Rezoning Petition Review

Date of Review: December 19, 2007

Rezoning Petition #: 08-37

Location of Property: Approximately 1.12 acres located on the north side of E Morehead Street, between Queens Road and Bromley Road.

REZONING PLAN

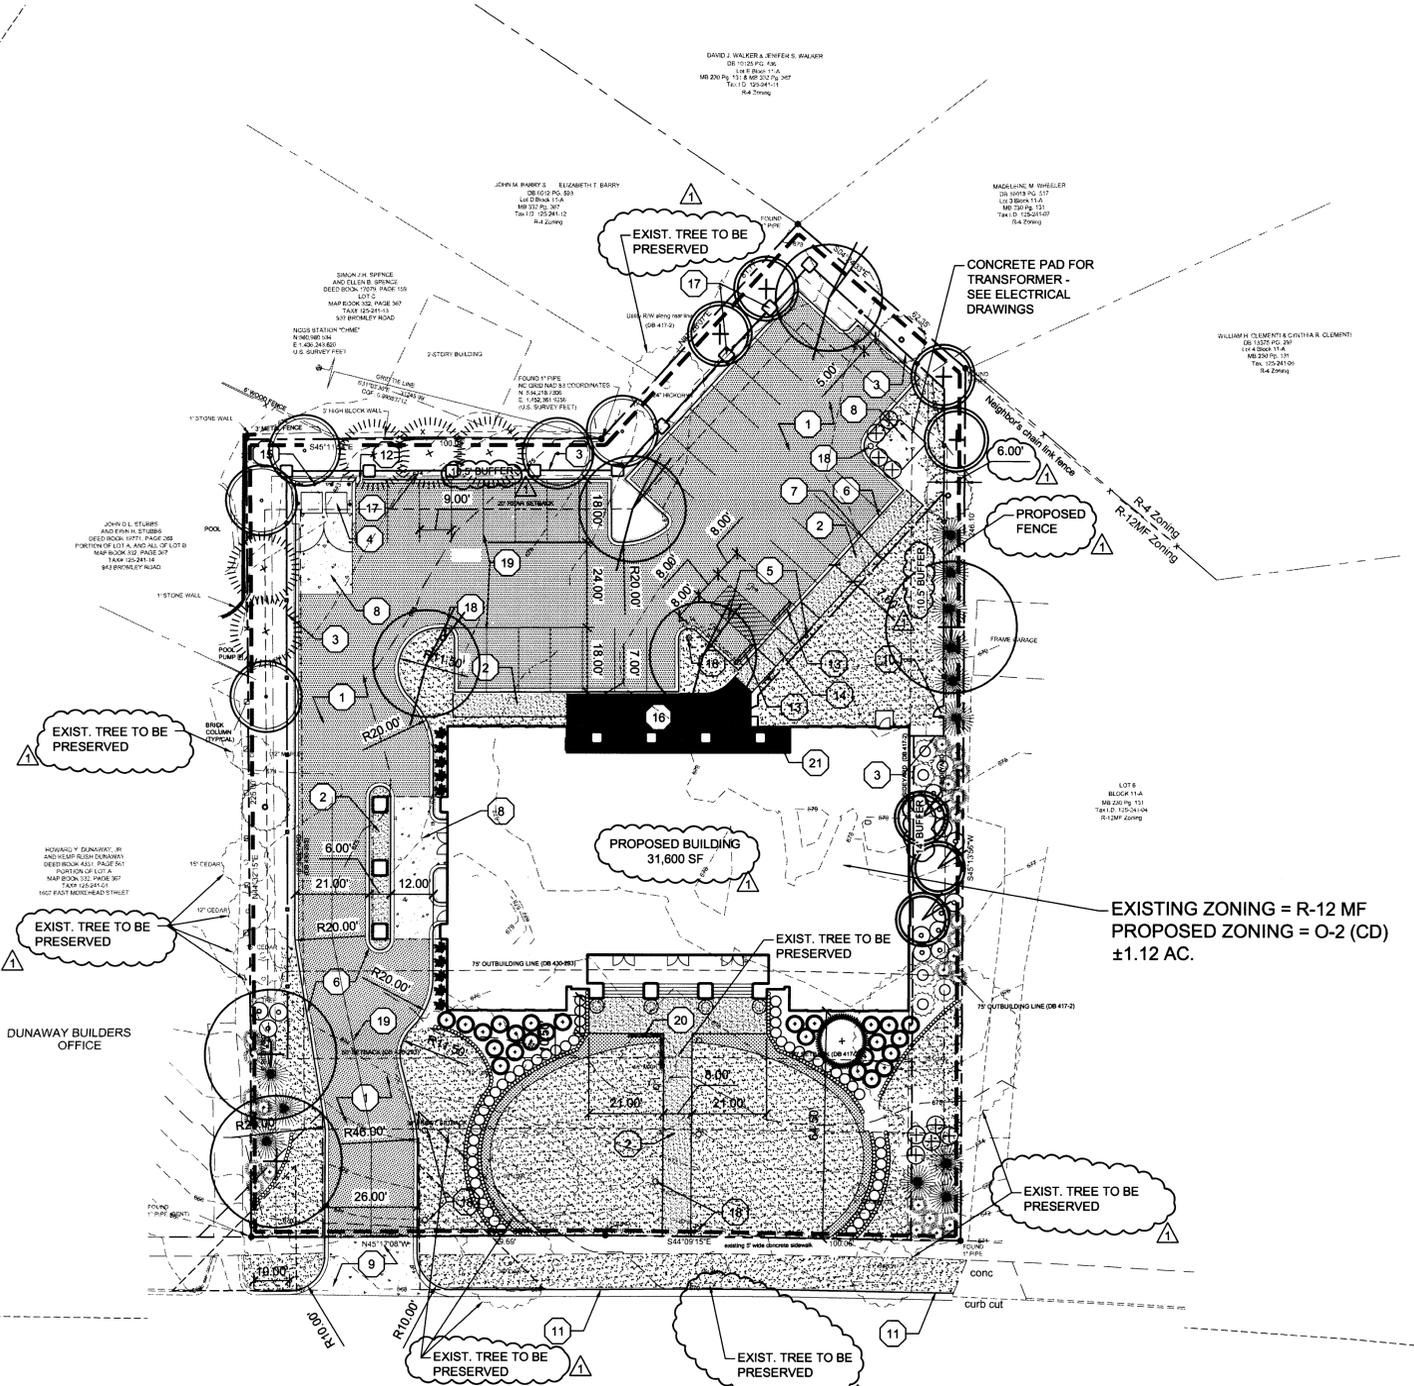
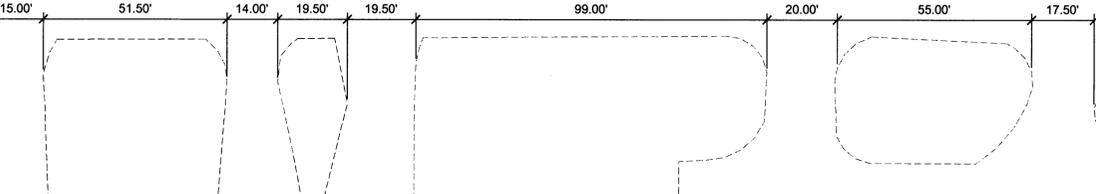
Concerning Storm Water: Include the following notes on the petition.

The petitioner shall tie-in to the existing storm water system(s). The petitioner shall have the receiving drainage system(s) analyzed to ensure that it will not be taken out of standard due to the

development. If it is found that development will cause the storm drainage system(s) to be taken out of standard, the petitioner shall provide alternate methods to prevent this from occurring.

For projects with defined watersheds greater than 24% built-upon area and greater than one acre of disturbed area, construct water quality best management practices (BMPs) to achieve 85% Total Suspended Solid (TSS) removal for the entire post-development runoff volume for the runoff generated from the first 1-inch of rainfall. BMPs must be designed and constructed in accordance with the Mecklenburg County BMP Design Manual, July 2007 or North Carolina Division of Water Quality Stormwater Best Management Practices Manual, July 2007. (Design Standards shall be met according to the City of Charlotte Best Management Practices Manual, when available). Use of Low Impact Development (LID) techniques is optional.

For projects with defined watersheds greater than 24% built-upon area, control the entire volume for the 1-year, 24-hour storm. Runoff volume drawdown time shall be a minimum of 24 hours, but not more than 120 hours.

For residential projects with greater than 24% BUA and greater than one acre of disturbed area, control the peak to match the predevelopment runoff rates for the 10-year and 25-year, 6-hour storms or perform a downstream analysis to determine whether peak control is needed, and if so, for what level of storm frequency. “Residential” shall be defined as “A development containing dwelling units with open yards on at least two sides where land is sold with each dwelling unit.”

For commercial projects with greater than 24% BUA and greater than one acre of disturbed area, control the peak to match the predevelopment runoff rates for the 10-yr, 6-hr storm and perform a downstream flood analysis to determine whether additional peak control is needed and if so, for what level of storm frequency, or if a downstream analysis is not performed, control the peak for the 10-yr and 25-yr, 6-hour storms.

For commercial projects with less than or equal to 24% BUA, but greater than one acre of disturbed area, control the peak to match the predevelopment runoff rates for the 2 and 10-yr, 6-hr storm.
